Application for a non-material amendment following a grant of planning permission. Town and Country Planning Act 1990

P/96/14/NMA

Application for a non material amendment
following a grant of planning permission
P/56/13/ for revised windows/door to rear
elevation on line of original rear garage door
opening.

TITLE	
PROPOSED SIDE ELEVATIONS	
PROJECT	
8 HOOK LANE PAGHAM PO21 3NY	
CLIENT	
MR DAVID DEADMAN	
DRAWN	R Hollands
DATE	GROVE DESIGN AUGUST 2014
SCALE	1 : 100 @ A3
DRAWING NO	14-08-GD-145-08B
AMENDMENTS	(A) Amended rear elevation (B) Additional rear wall amends

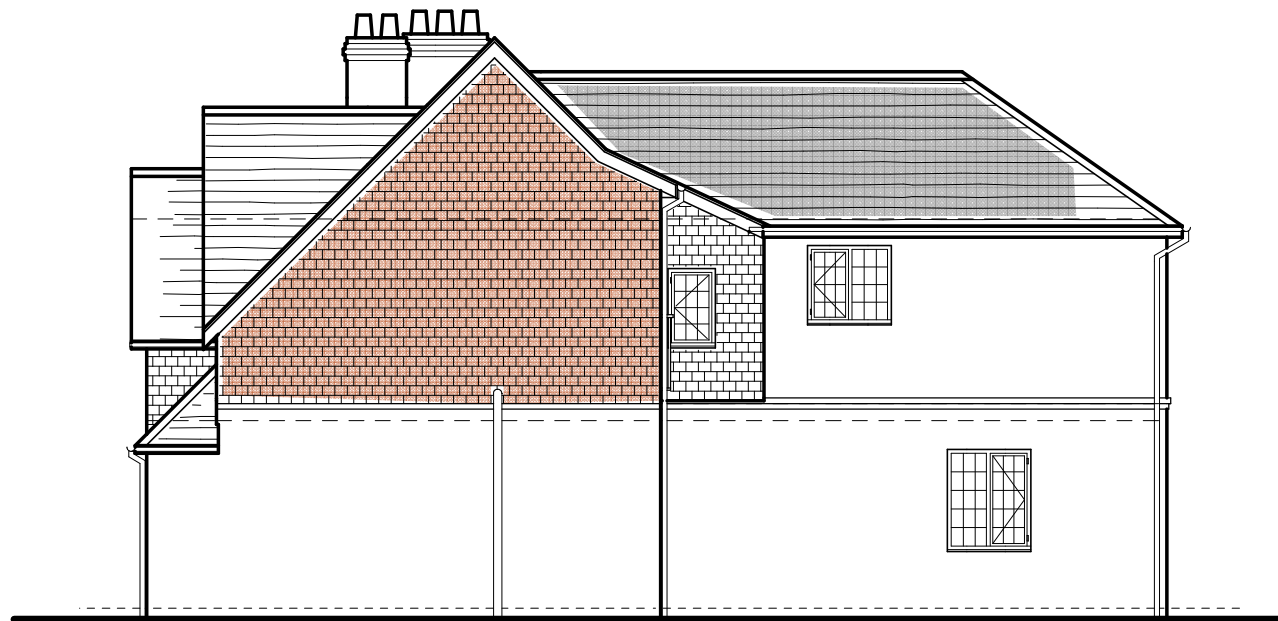
Revised windows / door to Rear Elevation on line of original Rear Garage door opening.
